**Re: Loves – Sunport at 3200 Broadway Blvd SE  
Erosion and Sediment Control Plan  
Engineer's Stamp Date 7/1/24 (M14E038)**

Based on the information in your submittal, received on 9/10/24, the ESC Plan and NOI cannot be approved for Building Permit or Work Order until the following comments are addressed.

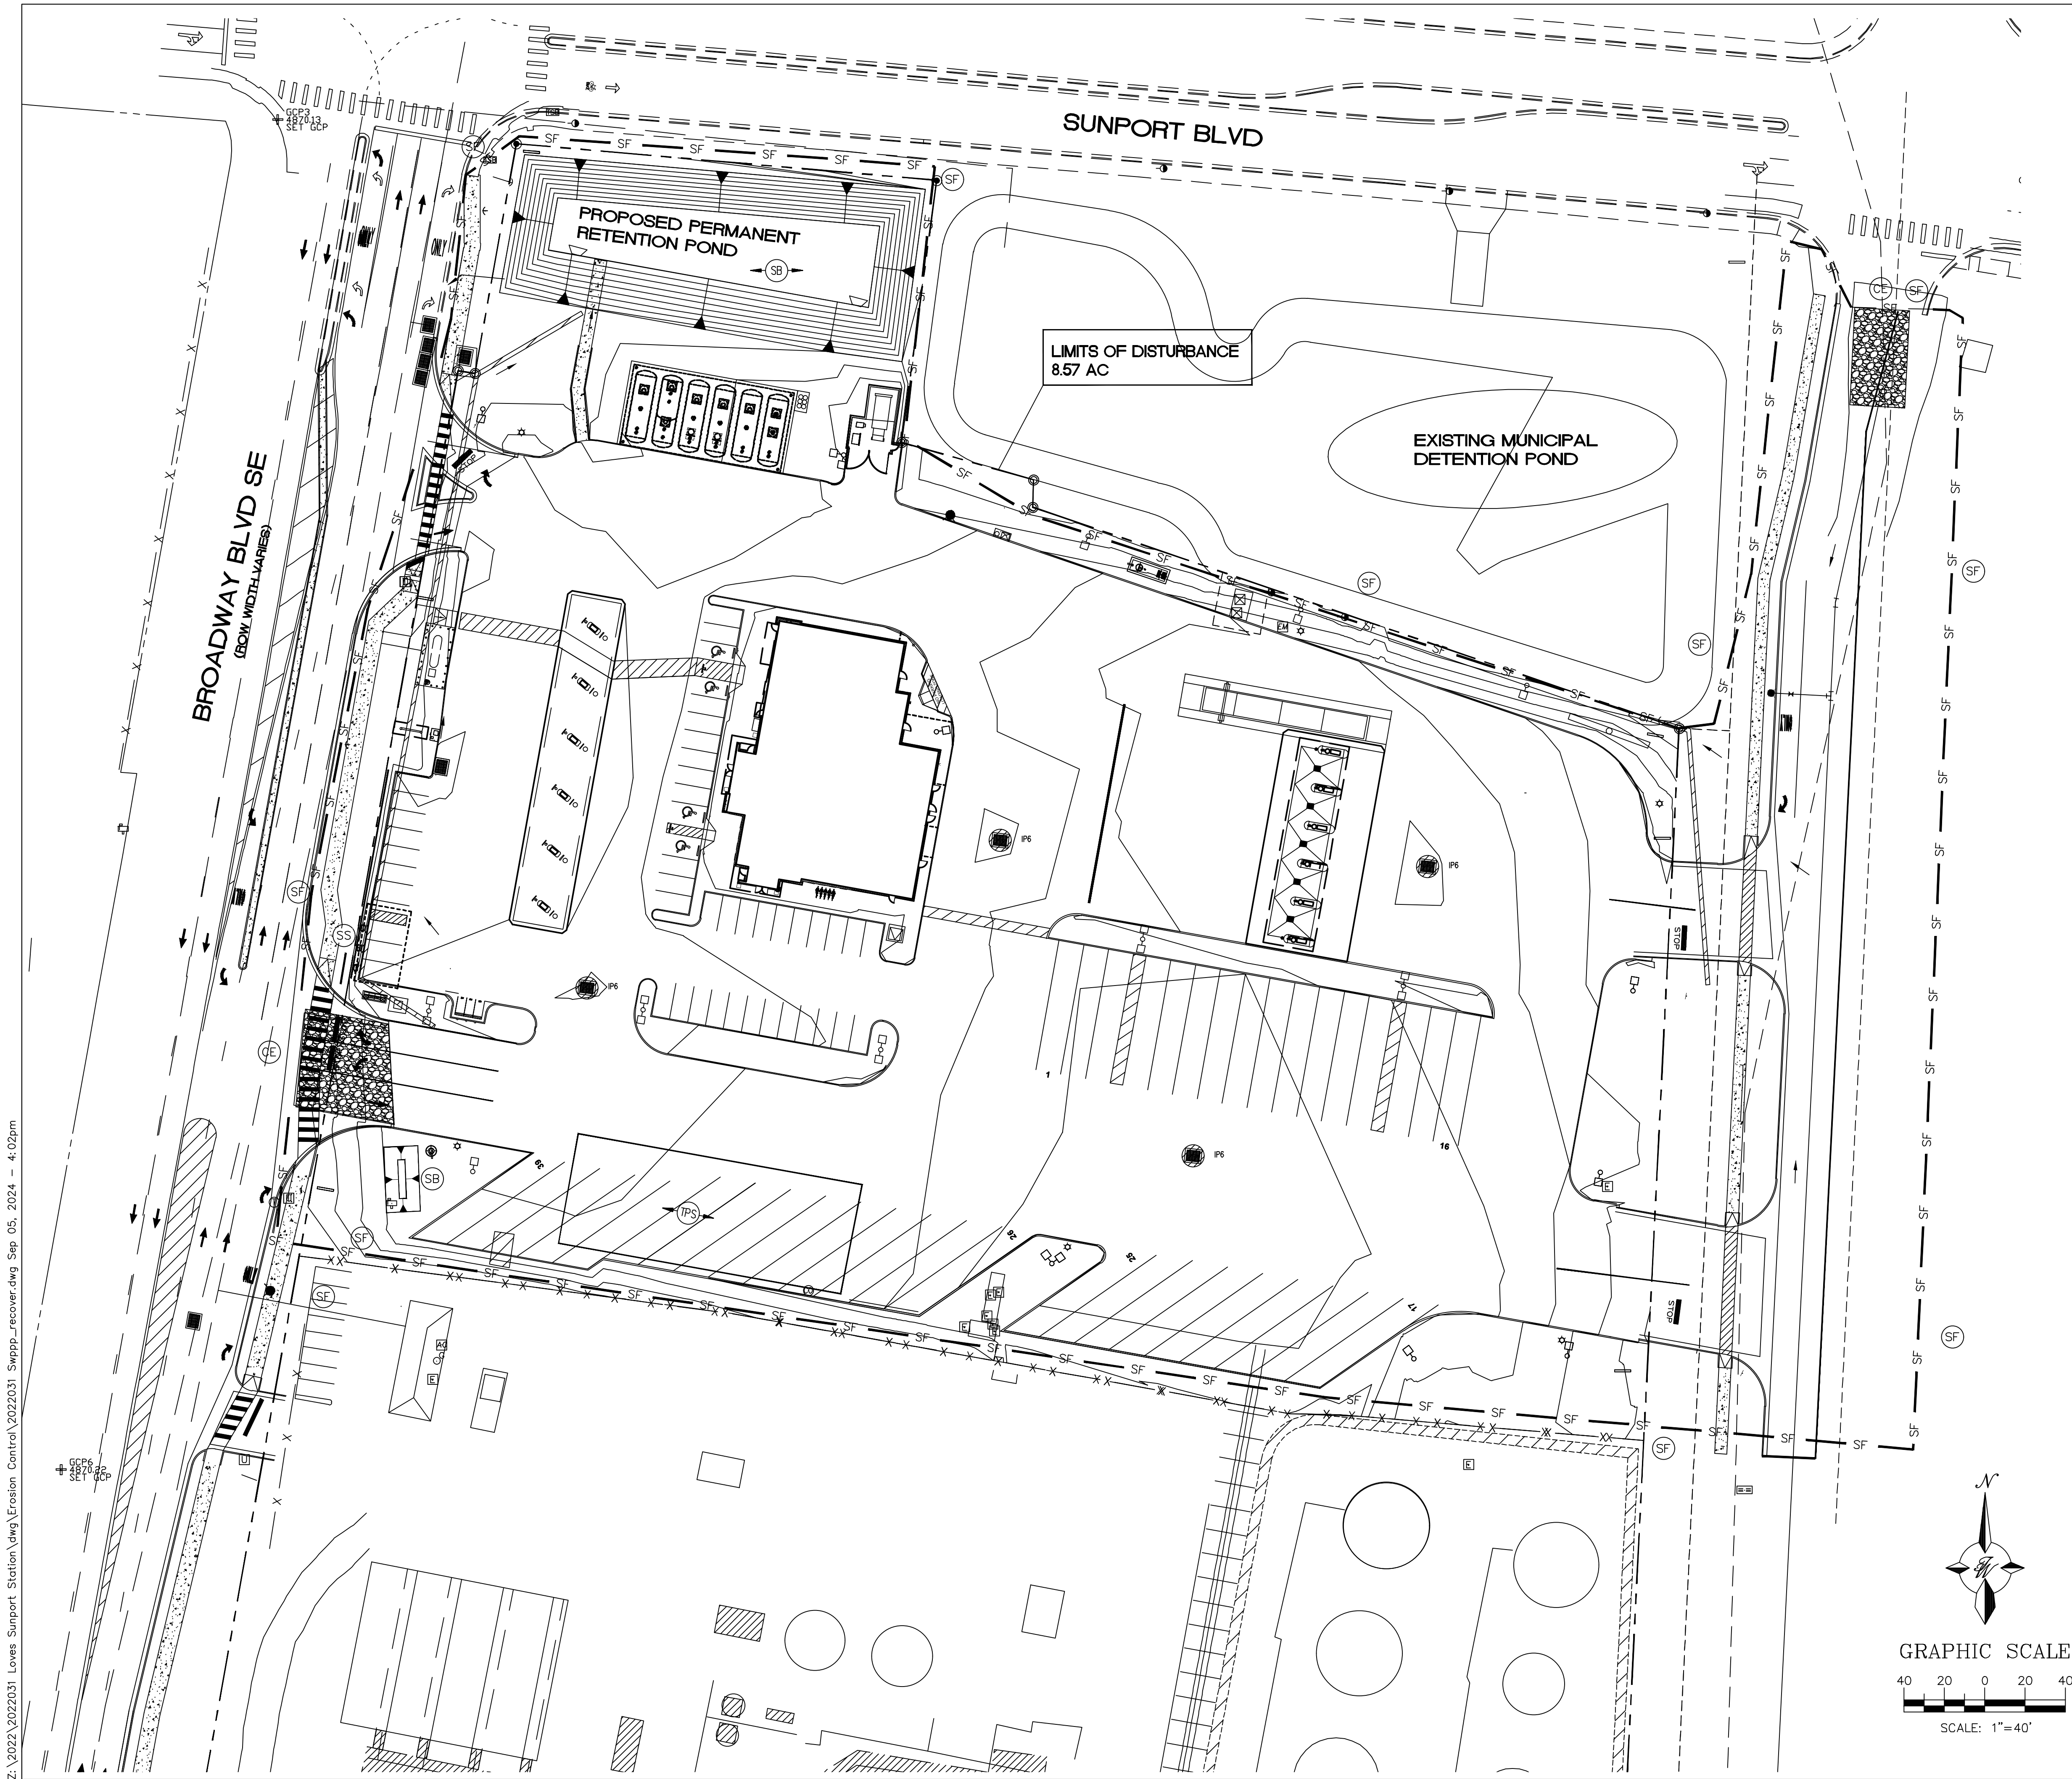
2. The existing grades are missing. The existing and proposed grades must be shown on the ESC Plan and agree with the Grading Plan approved by Hydrology per GP7.2.4.b.ii.

3. Add spot elevations to the temporary diversion berm along the west property line to ensure fall into the retention pond at the site's northwest corner. The berm may have to be more than 2' high in existing low spots.

4. Identify the required volume and specify both Sediment Trap (ST) dimensions. Some portions of the site may drain first to the south ST and then later to the north ST as grades change and storm sewer is added at different times during construction. They should both be sized for the largest area draining to them at any time during construction. Identify the portion of the pond that will be below grade and the embankment height and spillway width, if any. The spillway may not be needed if the required volume is below the lowest existing grade at the outlet. Identify the depth below the outlet where sediment removal is required.

5. Locate additional berms along the north and south boundary to ensure stormwater stays onsite and is diverted into the STs. Since existing grades are missing from the ESC Plan, it is difficult to tell where those berms may be needed.
